Your Ref: ABP-315920-23

RE: – Scart Mountain Wind Farm, Co. Waterford.

From: SIDS <sids@pleanala.ie>
Sent: 20 November 2024 11:49
To: Michael Nolan
Subject: FW: ABP-315920-23 - Scart Mountain Wind Farm - Drawing Scale request

SITE LAYOUT PLAN
- Sheet 1 of 10 -

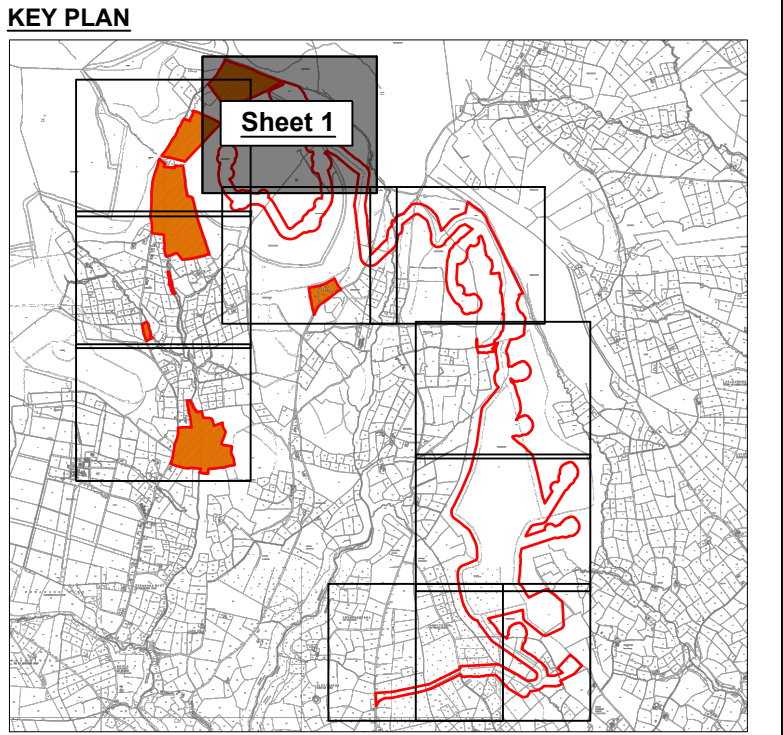
In relation to the above proposed development (your ref: ABP-315920-23), we wish to seek your feedback/approval for suggested drawing scales, which we propose for use in the Planning Drawings which will accompany the application (submission not yet made).

- 3 No. Site Layout Drawings to be produced at a scale of 1:5,000 (as in excess of 85 No. drawings would be required if the site layout plans were prepared at a scale of 1:500).
- 2 No. Site Location Drawings to be produced at a scale of 1:10,000 (as in excess of 10 No. drawings would be required if the site layout plans were prepared at a scale of 1:2500).

Site layout drawings produced to a scale of 1:2500 are appropriate and I recommend that they are accompanied by a site layout key plan. The applicant is at liberty to provide layout drawings produced at a scale of 1:5000 as well.

The Board will accept the site location map to a scale of 1:10,000 but the site layout plans are required to be to a scale of 1:2500 to provide the necessary level of detail.
